Your Ref: OWPC24052
Our Ref: R/72/19/PL 02-04-2019
Please ask for:
Mrs A Gardner

Town & Country Planning Act 1990 (as amended)
Town and Country Planning (Development Management Procedure) (England) Order 2015

Demolition of existing garage & store on existing dwelling & construction of 2 new dwellings in rear garden.

6 Manor Road Rustington

DRAWING: PROPOSED NEW DWELLINGS - PLANS **SCALE:** 1:50 @ A2 **DATE:** 11/07/2019 **DRAWING No:** DS/6MANOR/04 rev 2

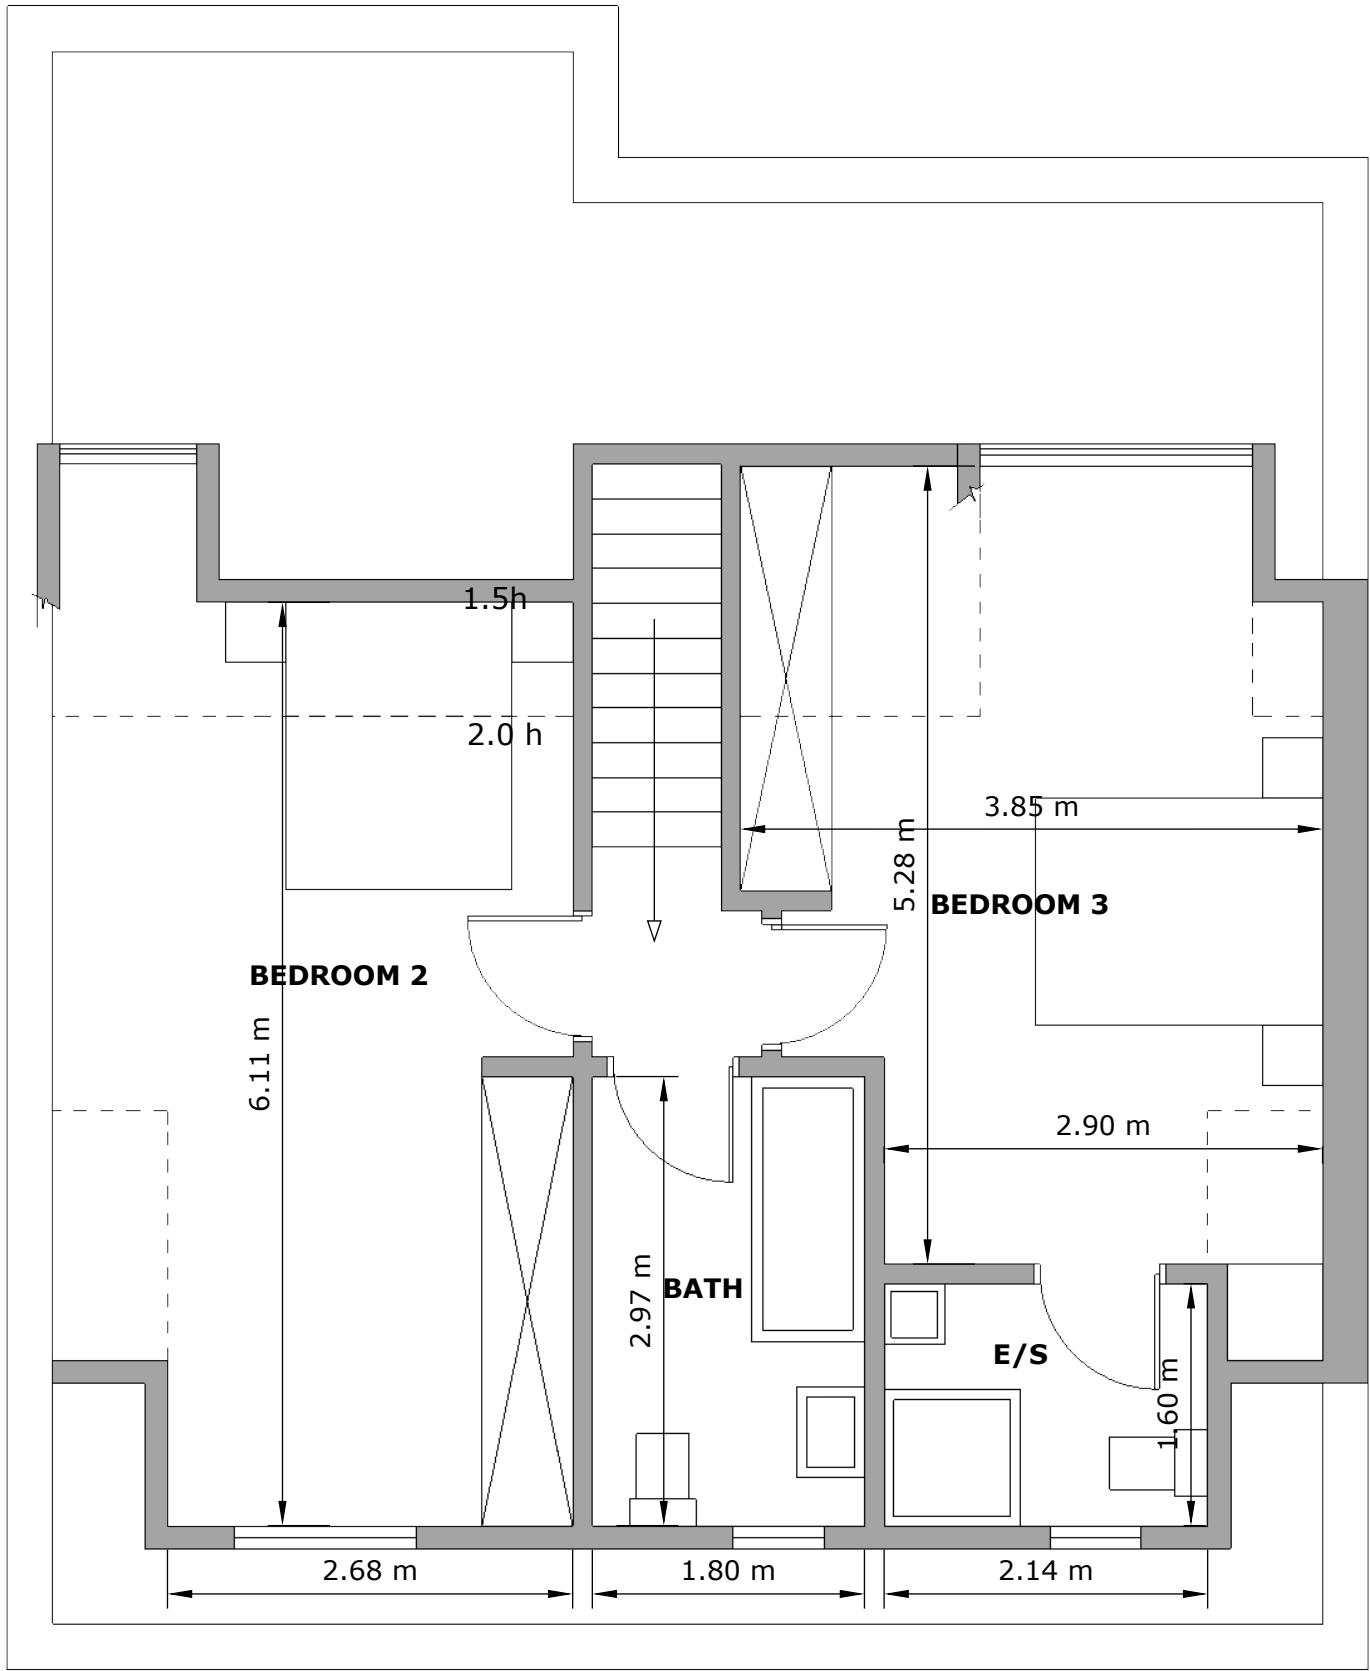
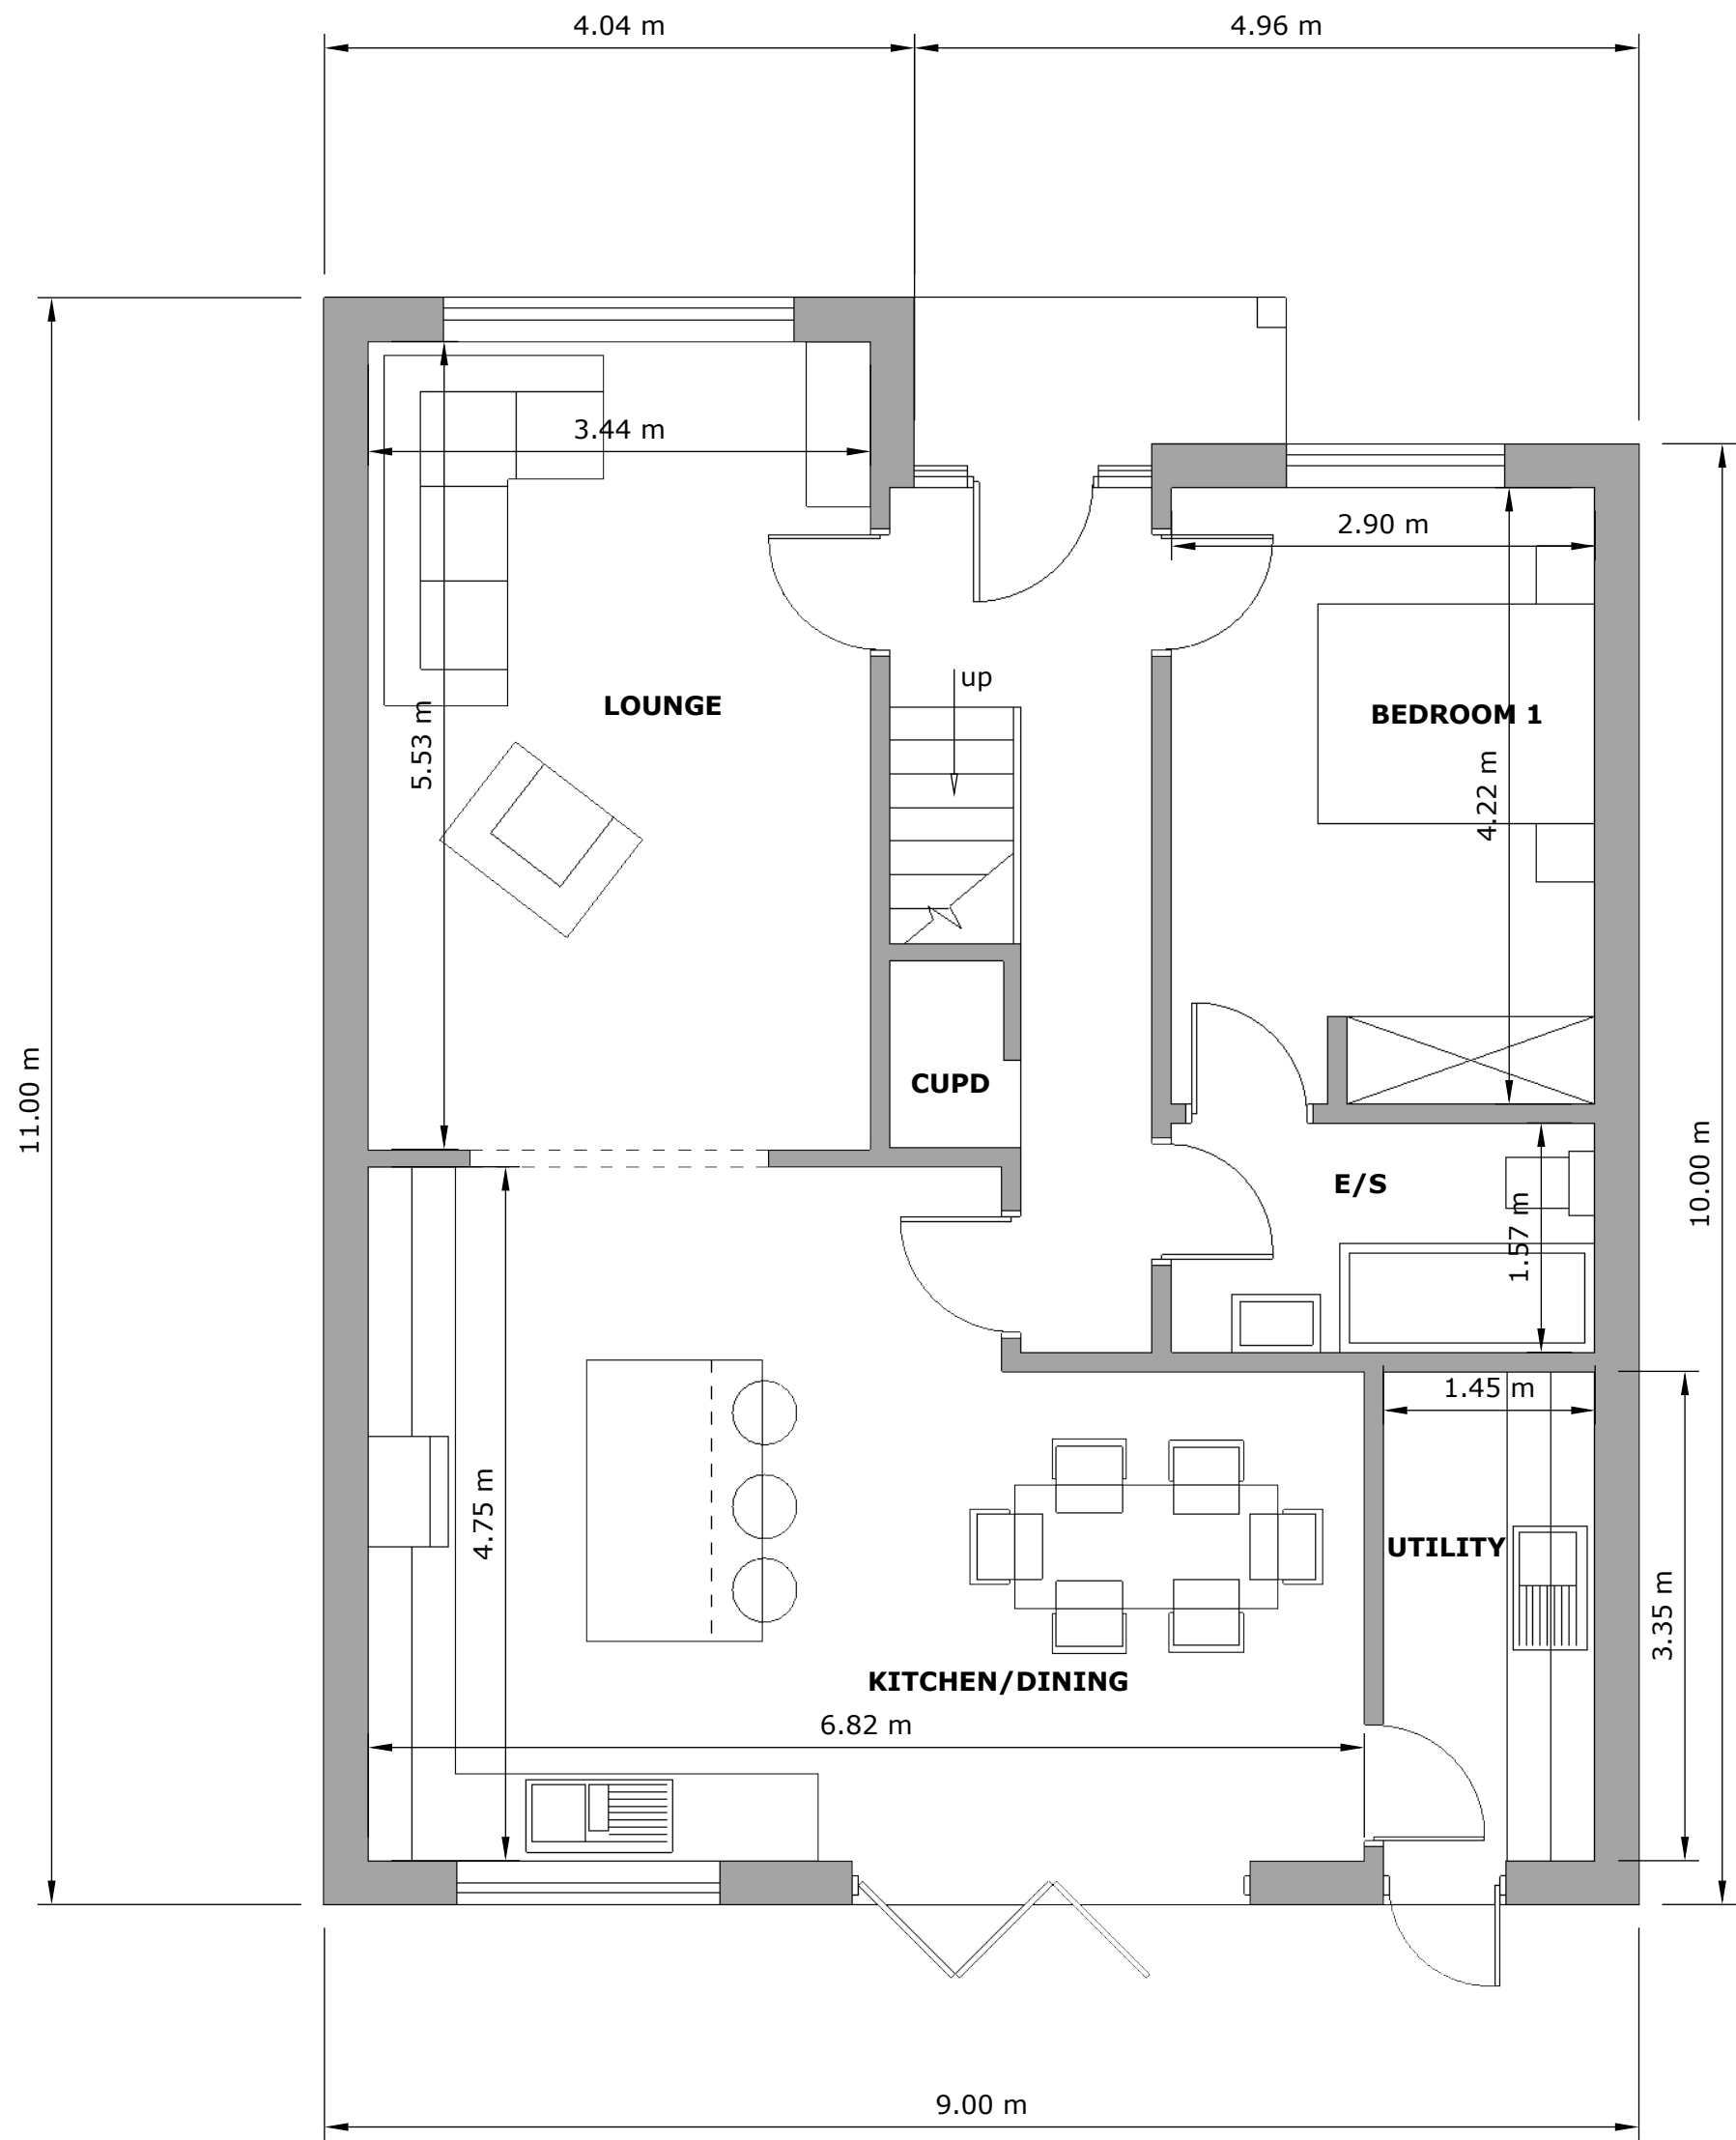
We would reinforce concerns already raised that the new builds do not comply with Policy 2: Housing Design of the Rustington Neighbourhood Plan (2014-19) in relation to 4.12 'New builds should be in scale to the locality and height restricted (to include roof space) to scale with similar nearby properties'

DRAWING No: DS/6MANOR/03 rev 4

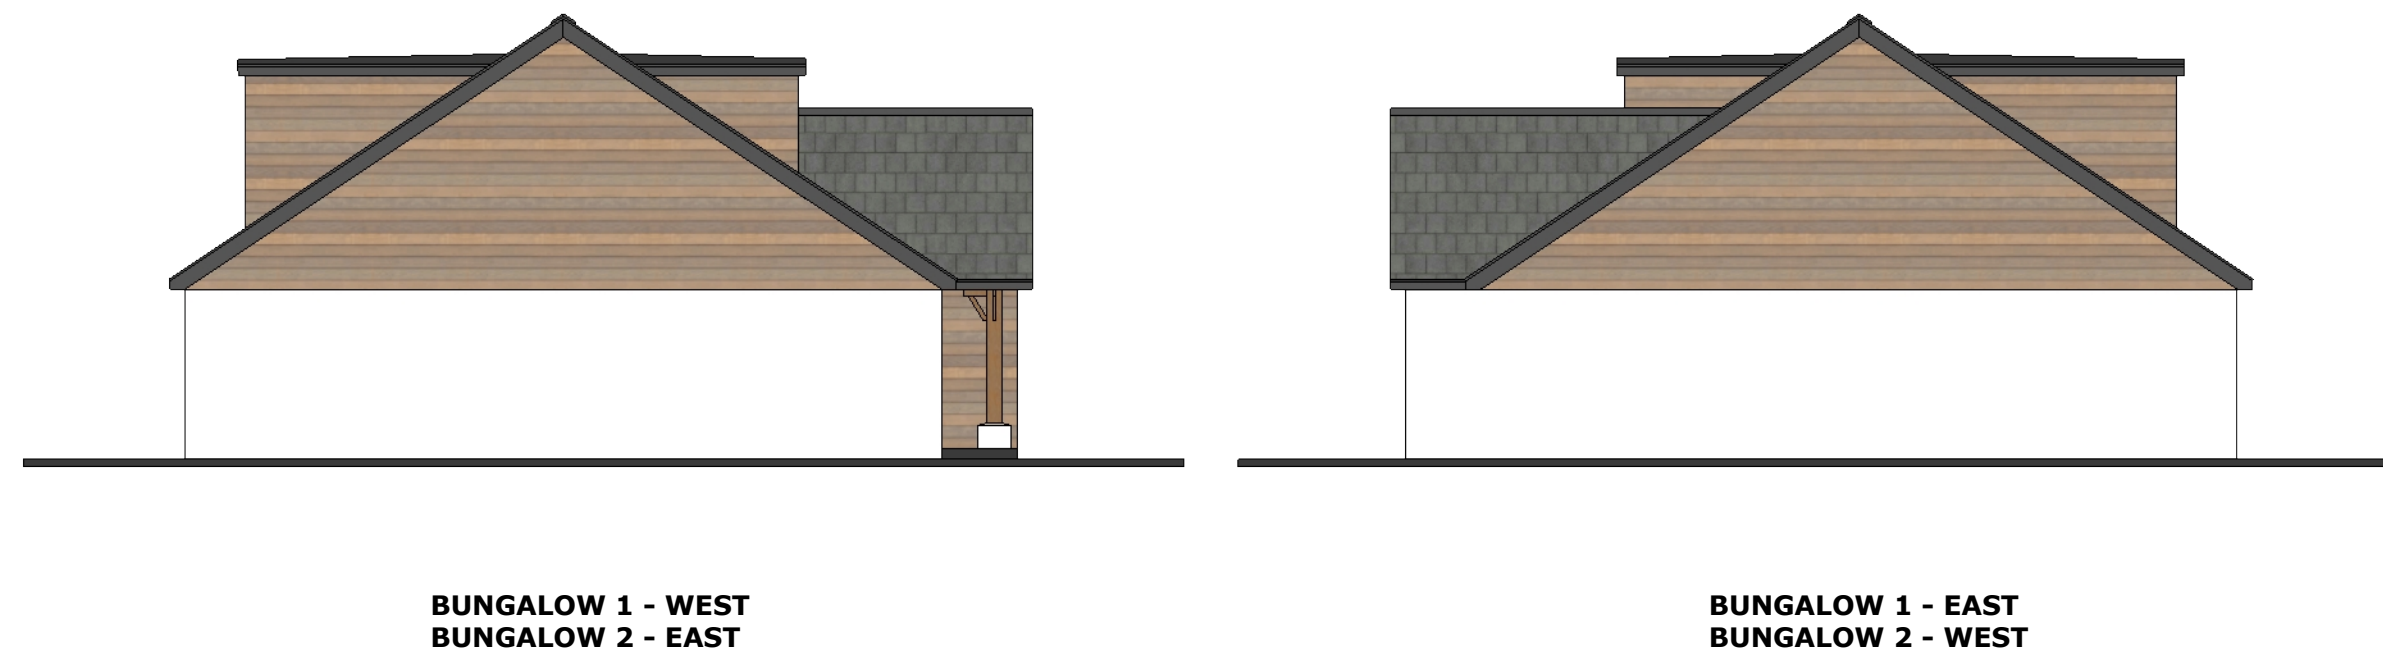
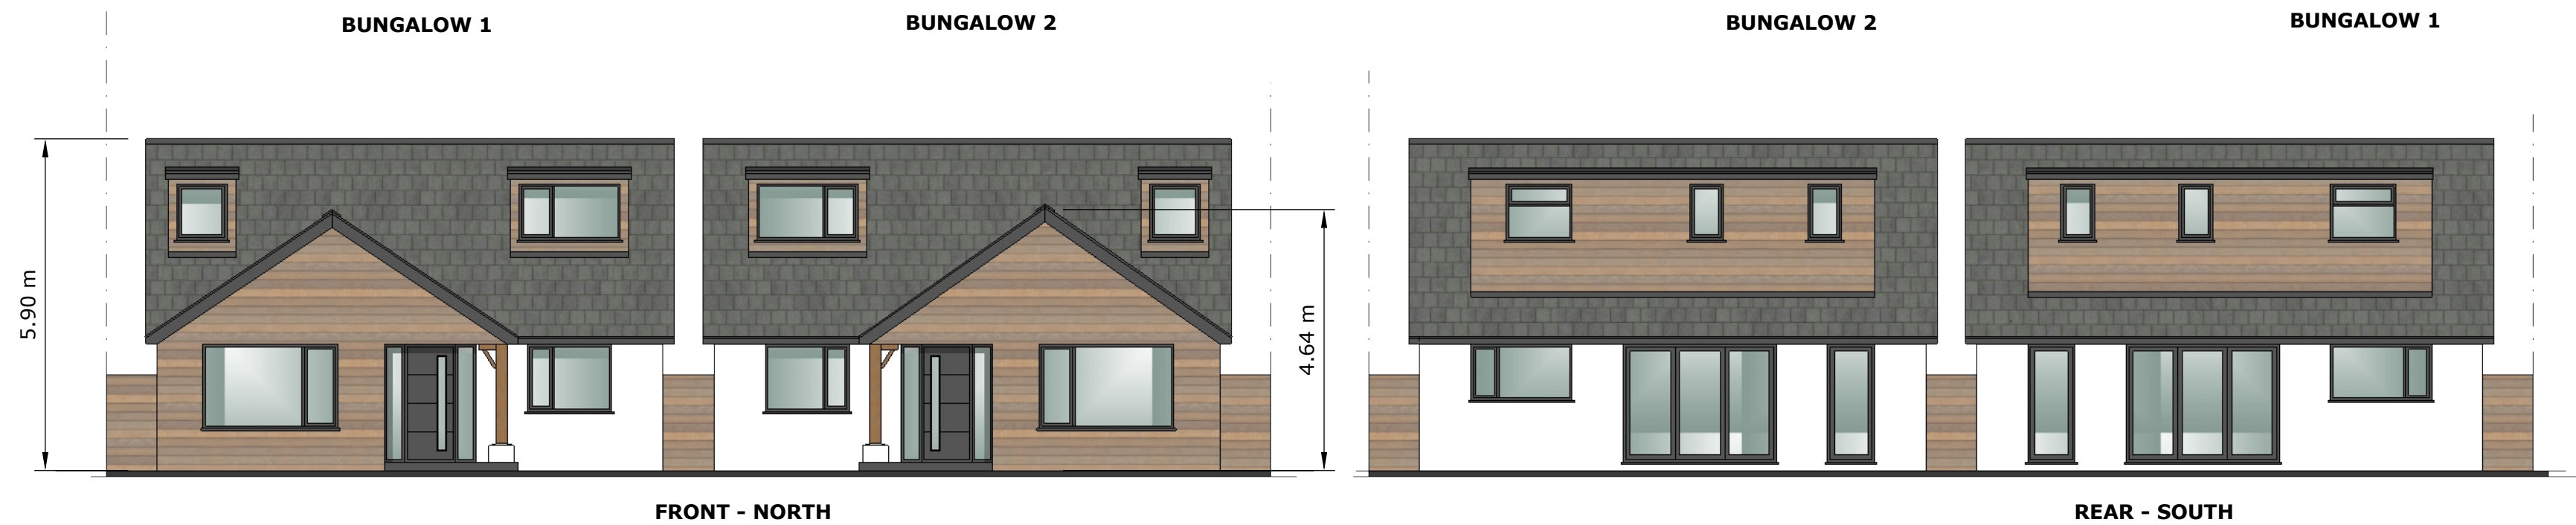
We wish to object to the proposed development on the adjacent property, 6 Manor Road, as we have serious concerns about privacy, particularly given the repositioning of the windows which will mean we are even more overlooked than originally planned. We also have serious concerns regarding the impact of noise and pollution both during the building process and from the finished properties.
